**RE: Discharge of Pre-Commencement Condition 19
Planning Permission: R/258/18/PL
Rustington Convalescent Home, Sea Road, BN16 2LZ**

A summary of this correspondence is provided alongside this application in a document titled “Nov 24 SW Drainage Comments”. This document highlights 25 points which are addressed in this application. A summary of how these points is addressed in this application is shown below, using the same numbering as in the letter:

Job Title		SEA ROAD RUSTINGTON, WEST SUSSEX	
Drawing Title		DRAINAGE LAYOUT SHEET 1 OF 3	
Client		MACAR HOMES (RUSTINGTON) LTD	
Scale	Date	Designed	AK
1:200 @A1	MAY 25		
Drawn	Checked	Approved	BAC
AK	BAC		
Job No	Drawing No	Rev	
25-043	25-043-105	B

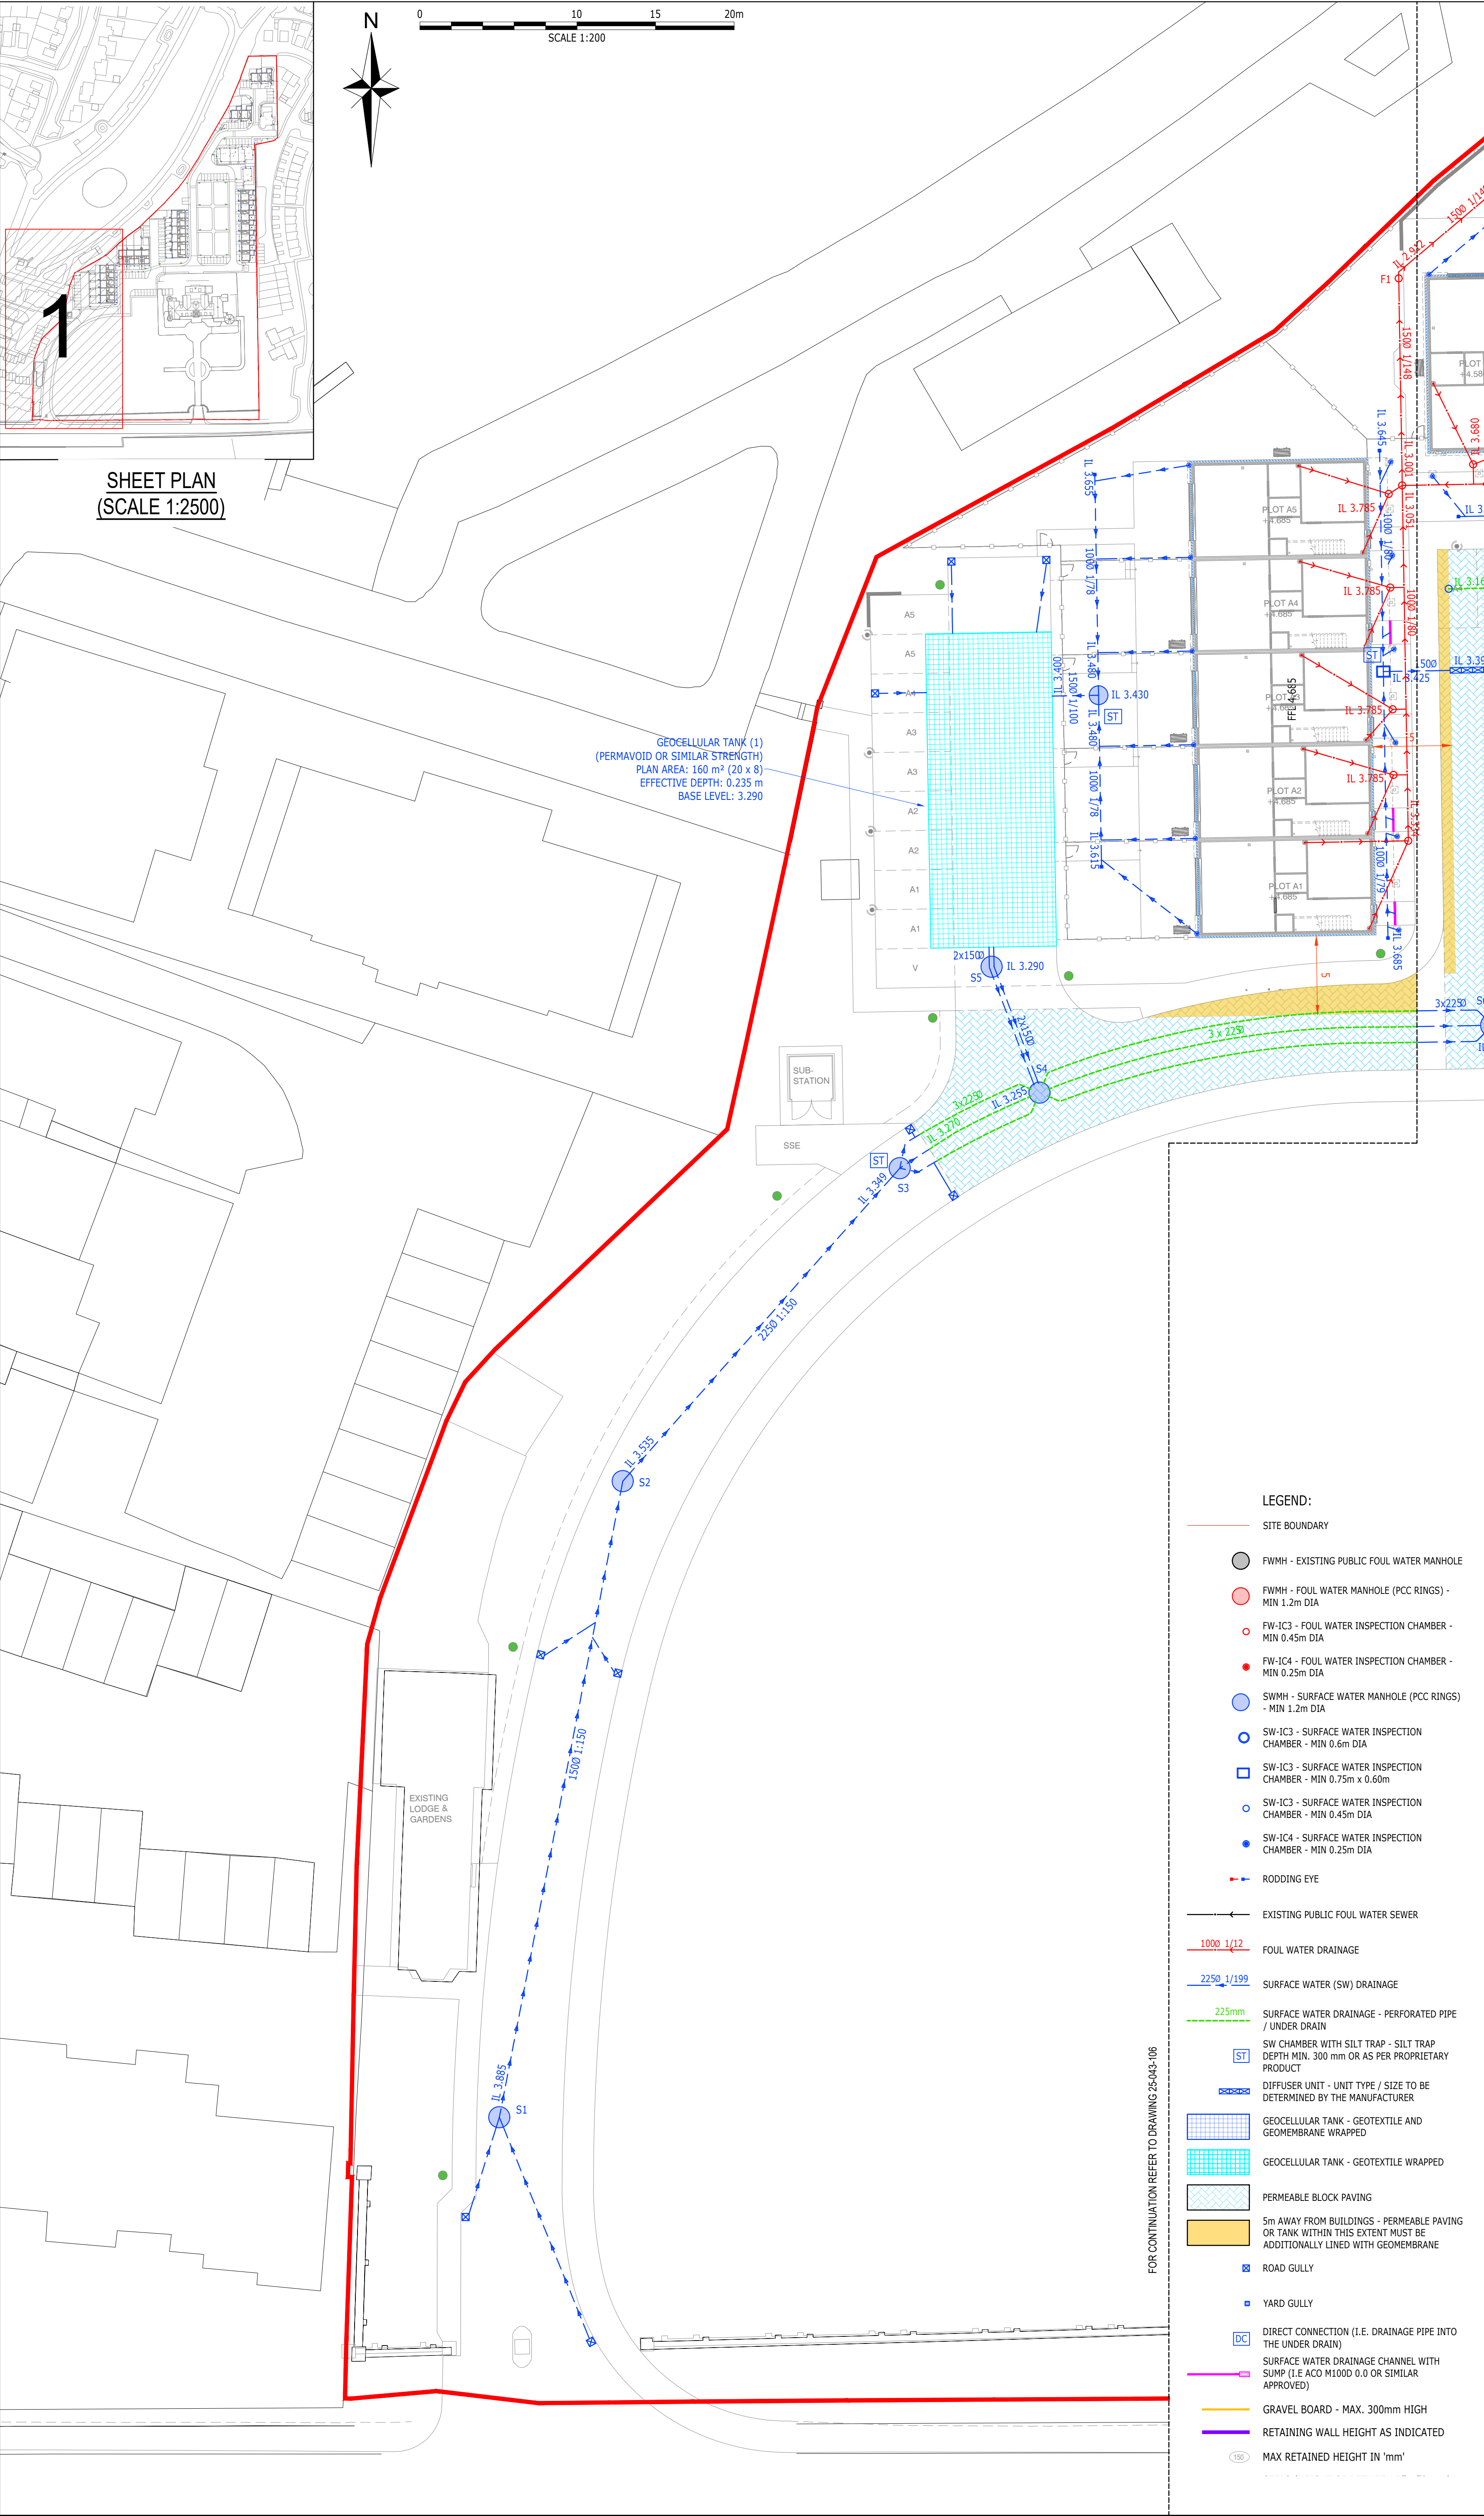
15. Diffuser units moved 5m away from structures where feasible. Please note that impermeable membrane is shown within 5m away from structures thus diffuser units could be installed closer than 5m in such instances – as water infiltration would be taking place 5m away from structures.
